From: [Mau, Russell E \(DOH\)](#)
To: [Dusty Pilkington](#)
Cc: [Serr, Ben A \(DOH\)](#); [Holly Duncan](#); [Holly Myers](#)
Subject: RE: CU-15-00007 NW Champanzee PH Comments
Date: Tuesday, July 26, 2016 3:32:18 PM

From: Holly Myers
Sent: Tuesday, July 26, 2016 3:03 PM
To: Dusty Pilkington
Subject: CU-15-00007 NW Champanzee PH Comments

SITE PLAN

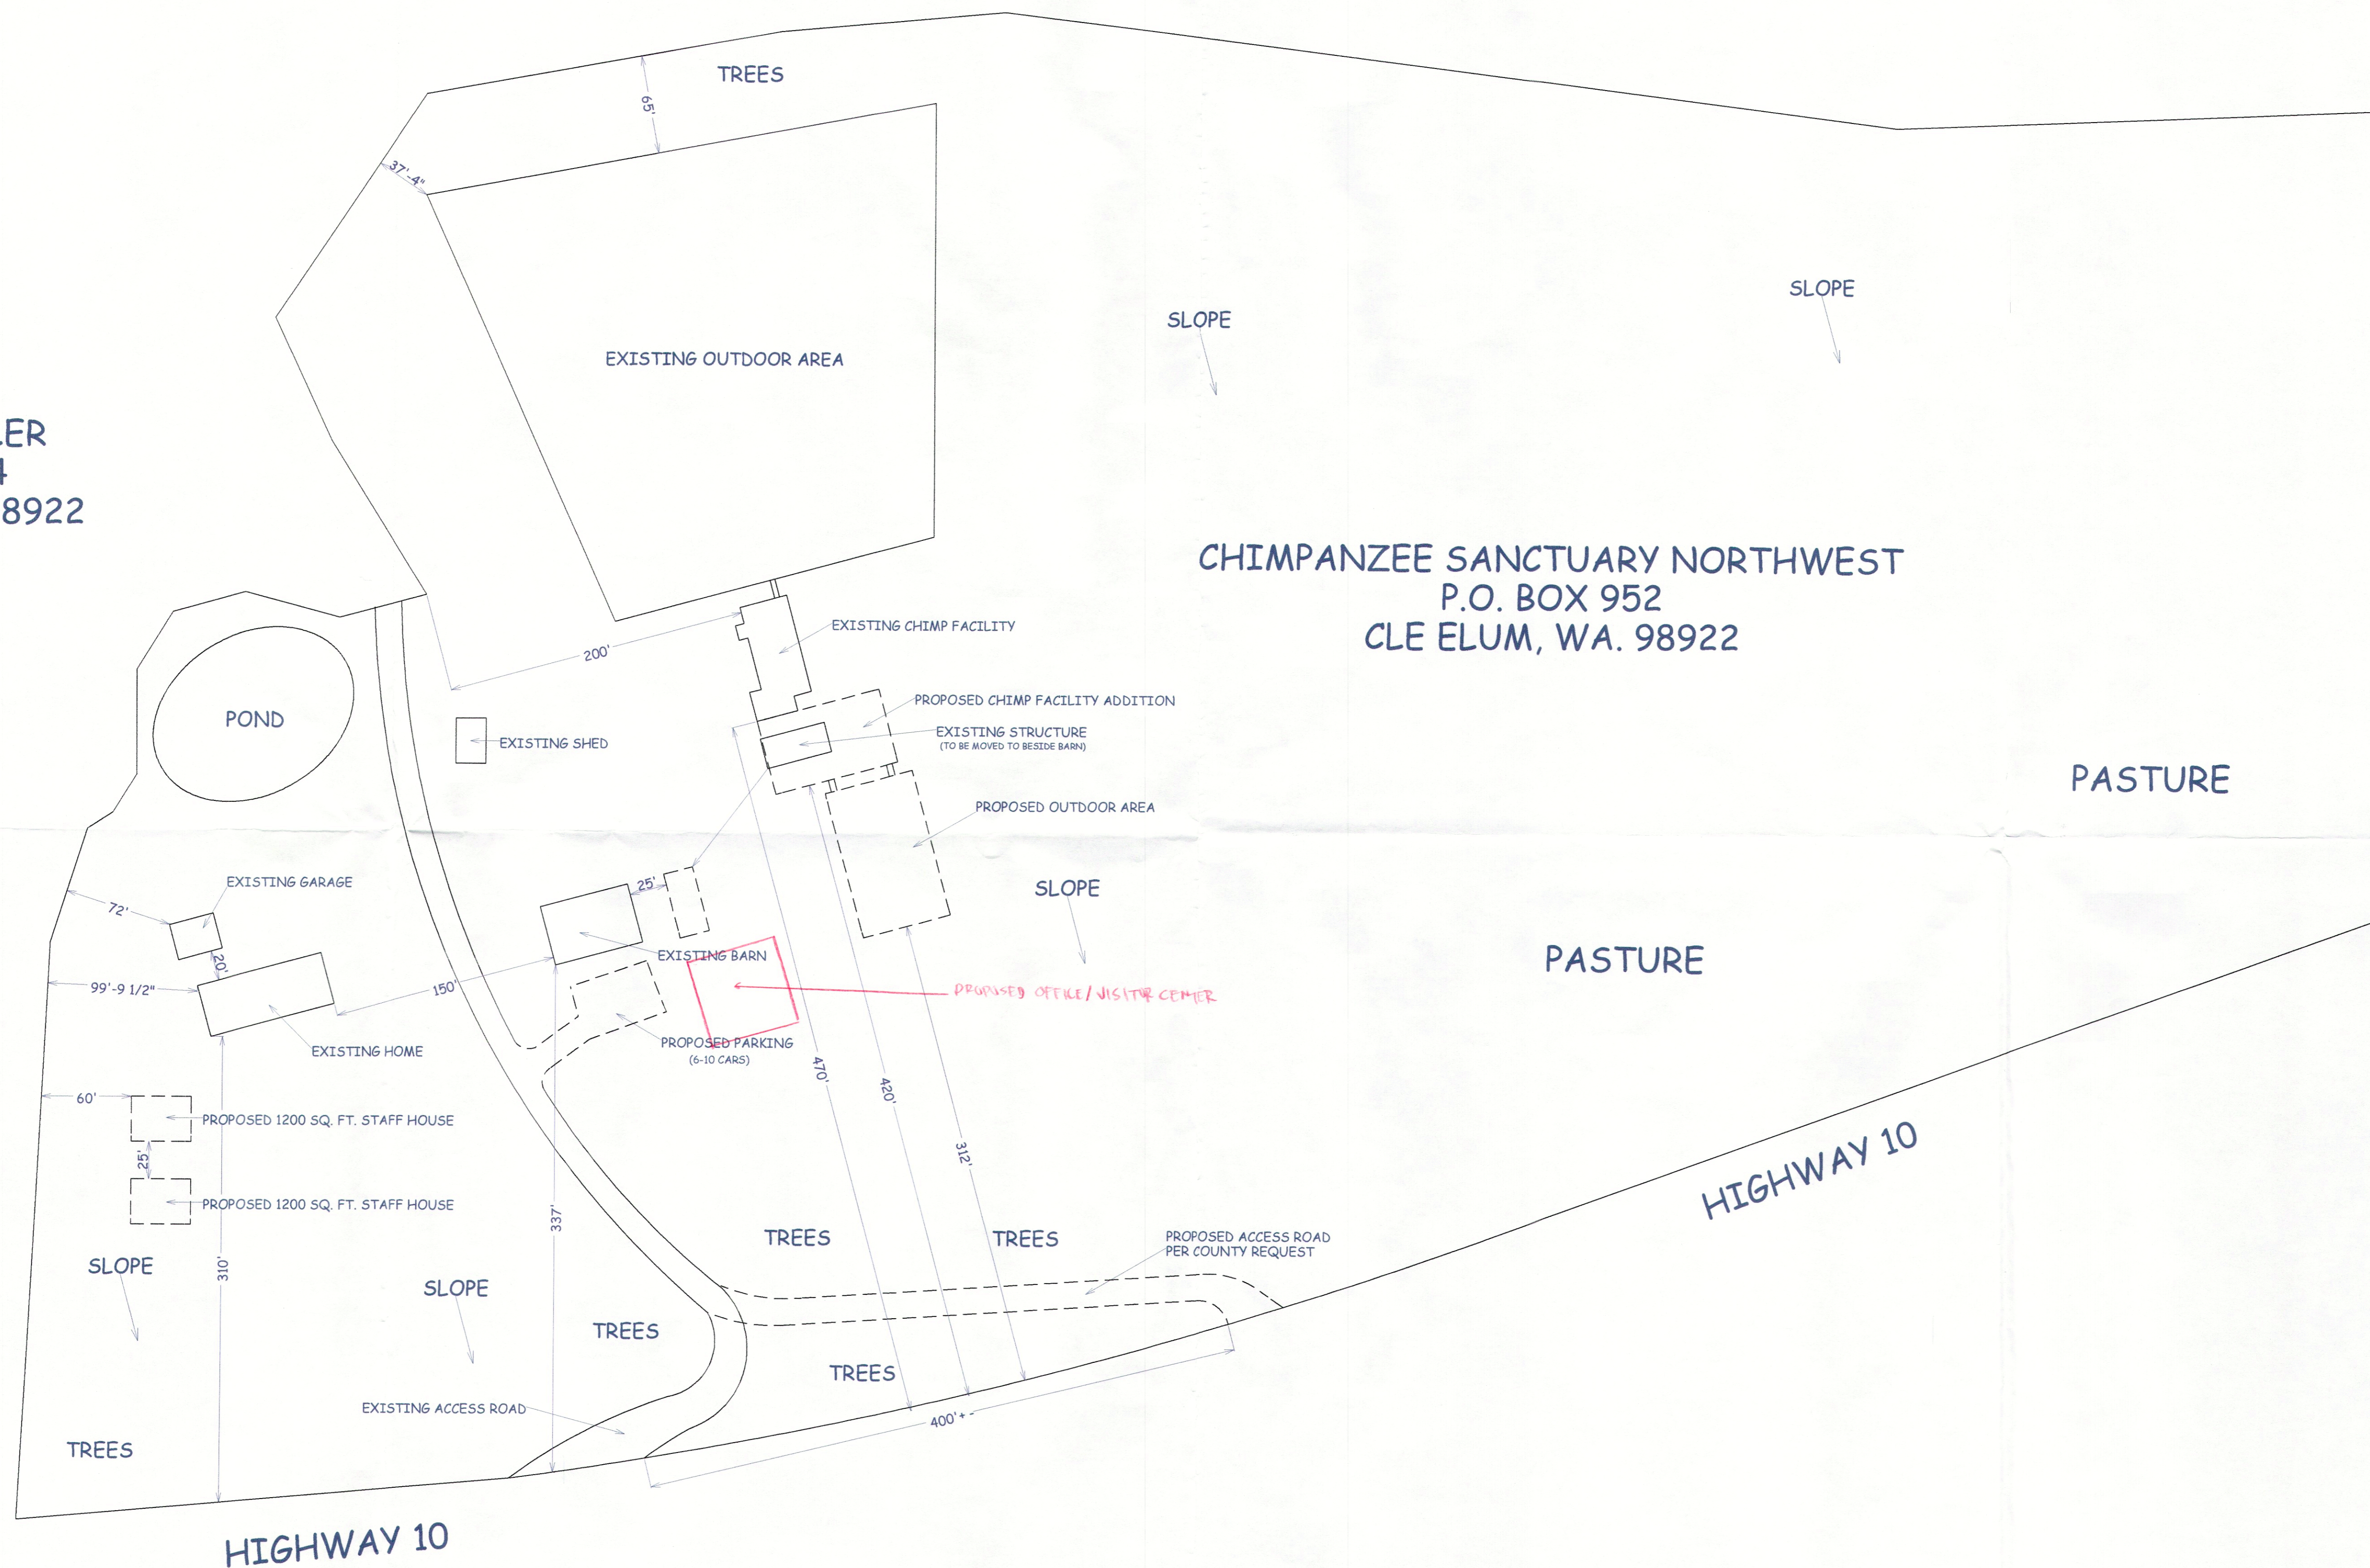
My previous comment is still applicable (see attached email); in addition, with the given population numbers meeting a criterion for being a Group A water system, DOH agrees that adding onto this water system would result in the need for a re-classification to a Group A water system. This reclassification requires a Group A application submitted to DOH for review and approval.

The water system (Hart Ranch ID#: AA391M) needs an updated nitrate test done to be up to date on testing.

The numbers of people they indicate will be using the water system are higher than the numbers that are shown on the current WFI form. An update to the current WFI form will need to be done showing the accurate numbers of regular non-residential users. The numbers in the project narrative indicate the system may need to be re-classified to a Group A system in which case they will need to work with DOH on that approval and upgrade prior to the addition of users.

- A Capacity Analysis, required to be completed by a professional engineer licensed in the State of Washington.
- A Group A water system application.
